**From:** Contact Centre (CRM) <contact@ribblevalley.gov.uk>  
**Sent:** 05 March 2025 21:41  
**To:** Planning  
**Subject:** Planning Application Comments - 3/2025/0043 FS-Case-693361354

**Planning Application Reference No.:** 3/2025/0043

**Address of Development:** 2 Anderson Road  
Wilpshire  
BB1 9LZ

**A3.3**

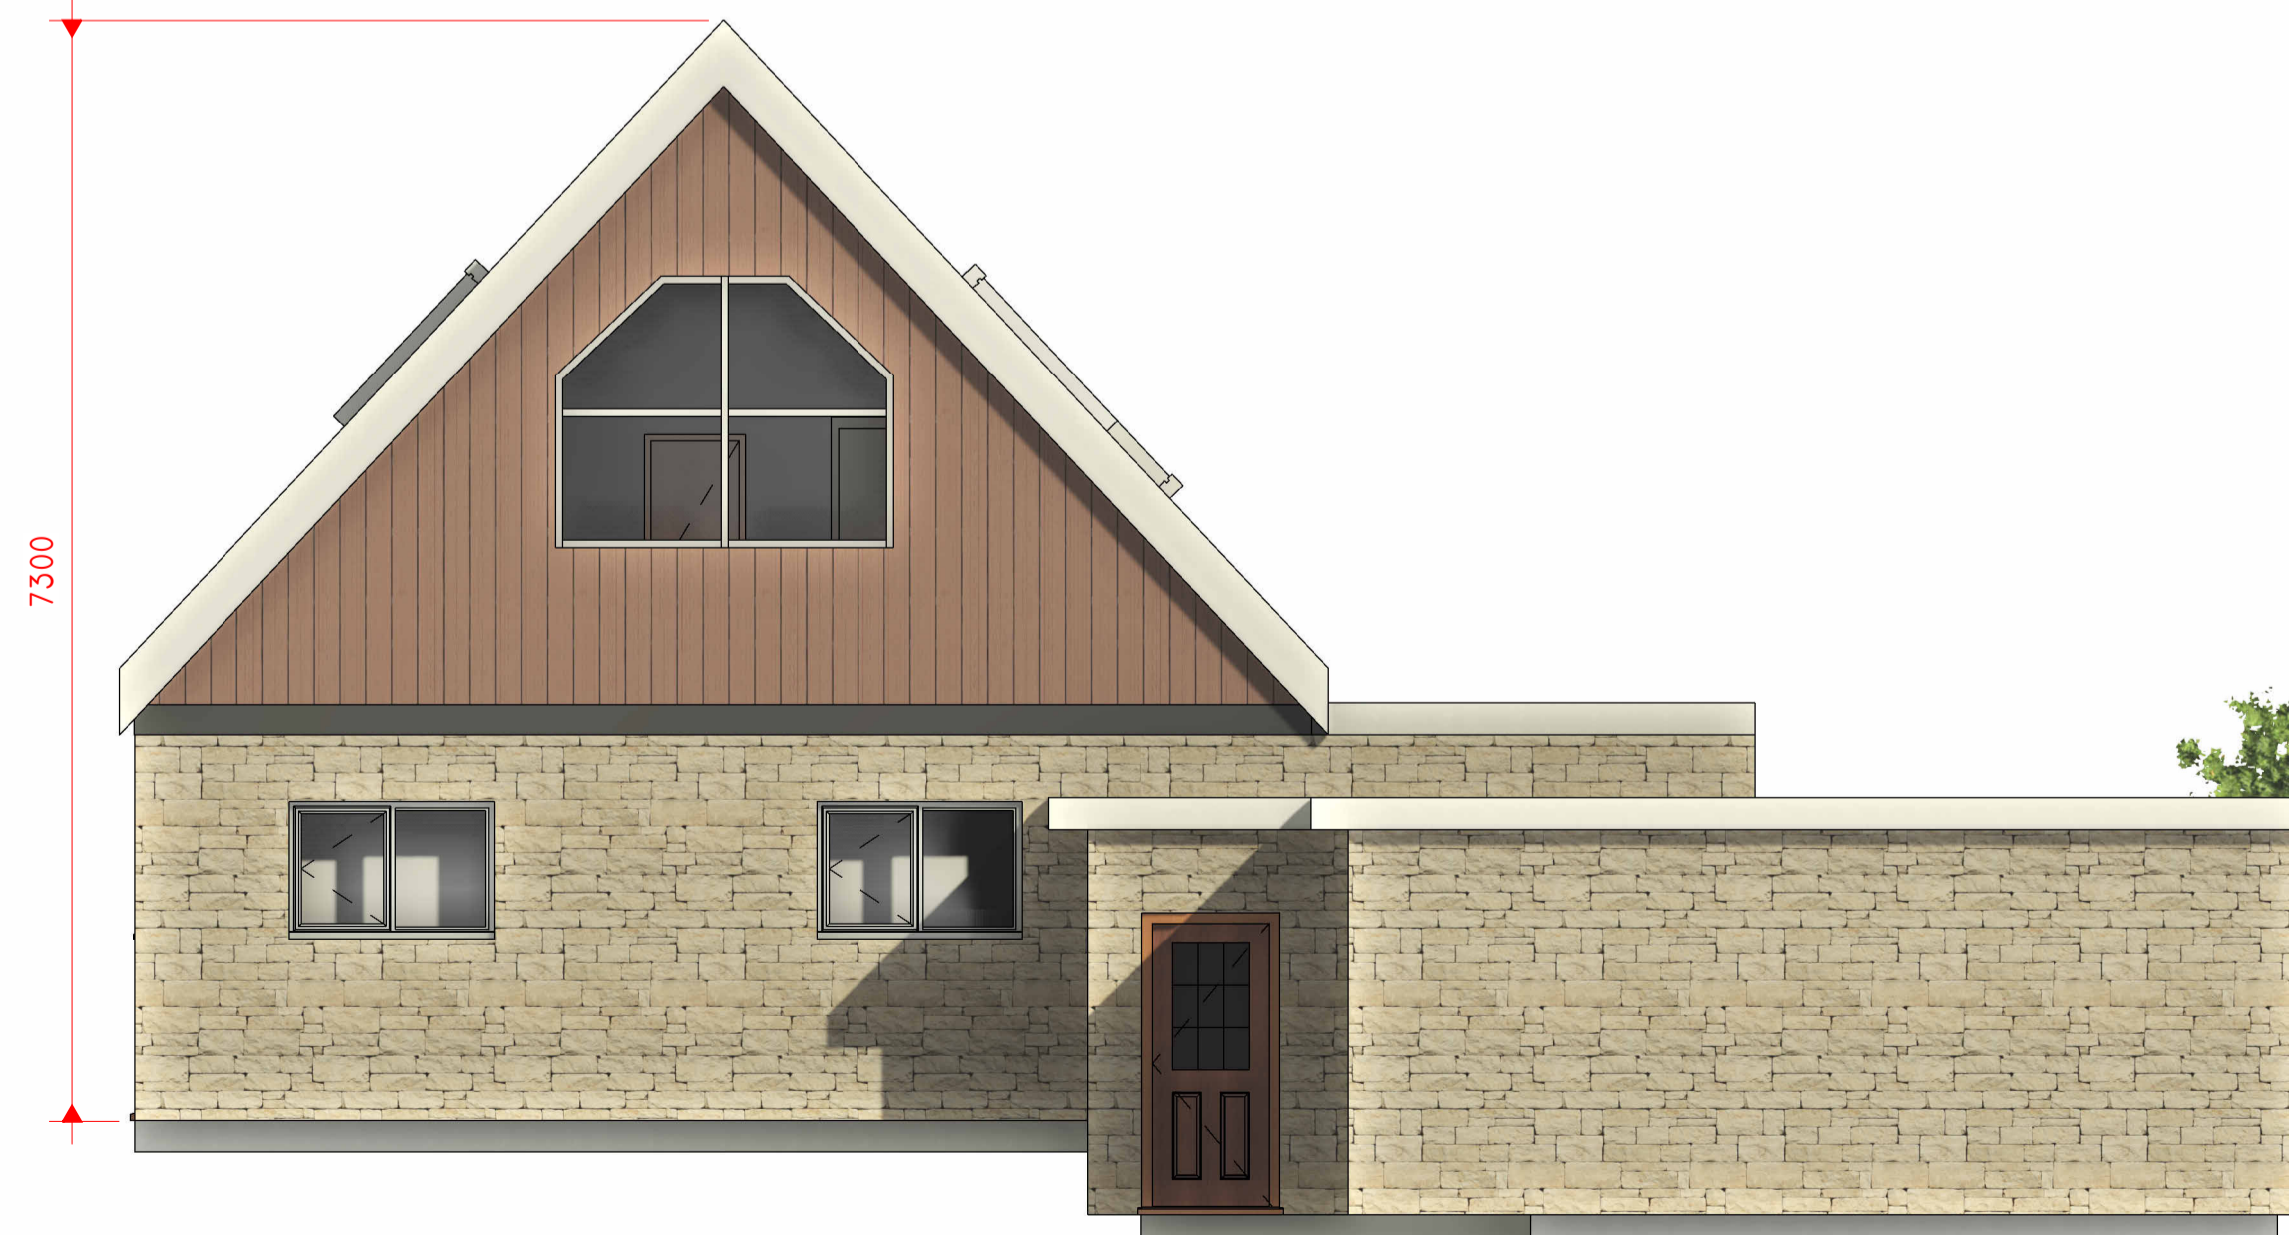
- 1) The veluxs [REDACTED]
- 2) The pitch of the roof would be too steep [REDACTED]
- 3) Obstructing the views
- 4) The architectural design wouldn't be in-keeping with the local area
